Rezoning Transportation Analysis

Petition Number: #2021-198

General Location Identifier: Tax ID 18712322

Date	Description
12-23-21	First Review (WB)
11-23-22	Second Review (IW)
02-22-23	Third Review (IW)
03-28-23	Fourth Review (IW)
04-05-23	Fifth Review (IW)

REZONING PETITION 2021-198

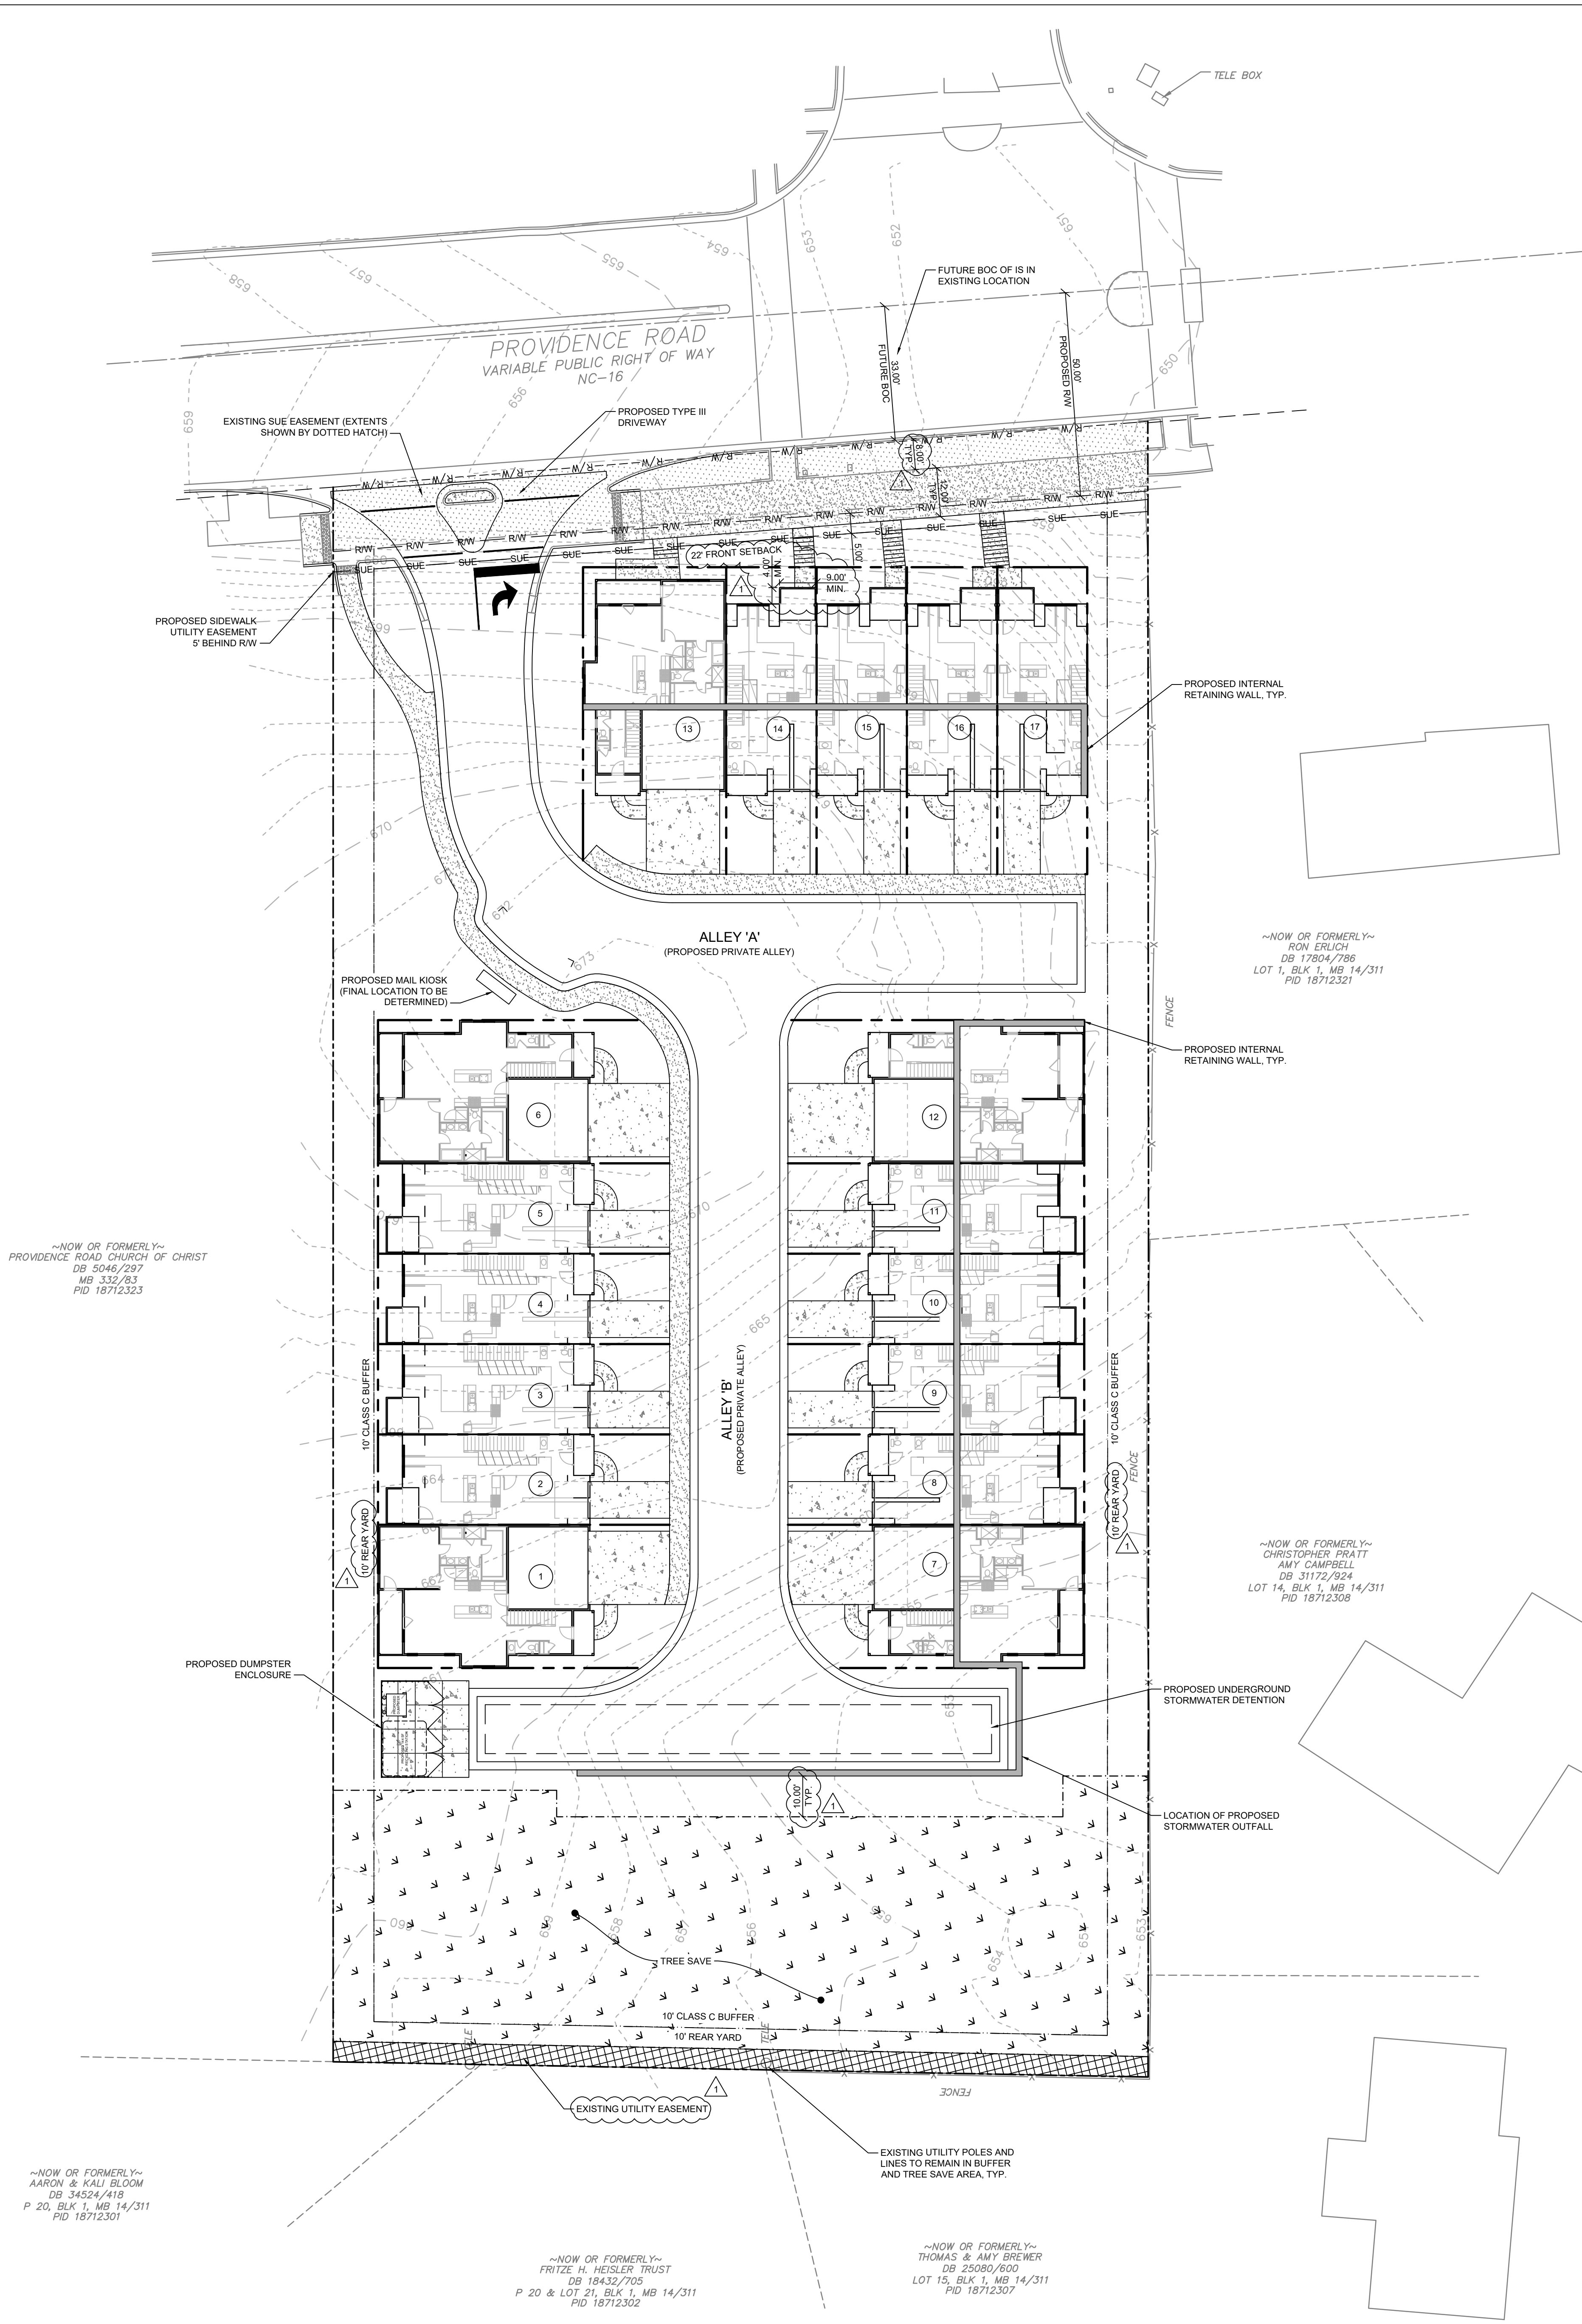
Clarifying comment 2-22-23: Per email exchange on 1-23-23, CDOT has informed the developer that the future back of curb is 33' from centerline. Site plan is currently showing 30' and suggesting the current curb and gutter is in the future location, this is incorrect. Adjust planting strip and 12' MUP accordingly.

4. ~~Outstanding Comment from 12-23-21~~ Revise site plan and conditional notes to commit to dedicate 50 foot right-of-way from the Providence Road centerline. The site plan shall label and dimension the right-of-way from the road centerline. (refer to Note 6. figure)
5. ~~Outstanding Comment from 12-23-2021~~ Site plan and conditional notes revisions are needed to commit to construct bicycle facilities by installing a 12' multi-use path with an 8' planting strip to meet the City of Charlotte BIKES Policy.

~~Clarifying Comment 2-22-23:~~ Site plan to include conditional note as well committing to an 8 foot planting strip and 12' multi-use path.

6. ~~Outstanding Comment from 12-23-2021~~ Revise site plan and conditional notes to commit to dedicate 5 foot sidewalk utility easement measured from the proposed right-of-way. CDOT requests that no steps be located within the SUE as the future sidewalk will be constructed therein. The site plan shall label and dimension the SUE from the proposed right-of-way.

8. ~~New Comment Based on 11-04-22 site plan:~~ The relocated driveway now creates a conflict with access to building. Revise and update site plan so that ramp leading to driveway access does not conflict with access to building.

The site has committed to relocating the proposed private driveway away from the signalized intersection per NCDOT's requirements, labeling and dimensioning the right-of-way, and installing planting strip and multi-use path. All outstanding CDOT issues have been addressed.
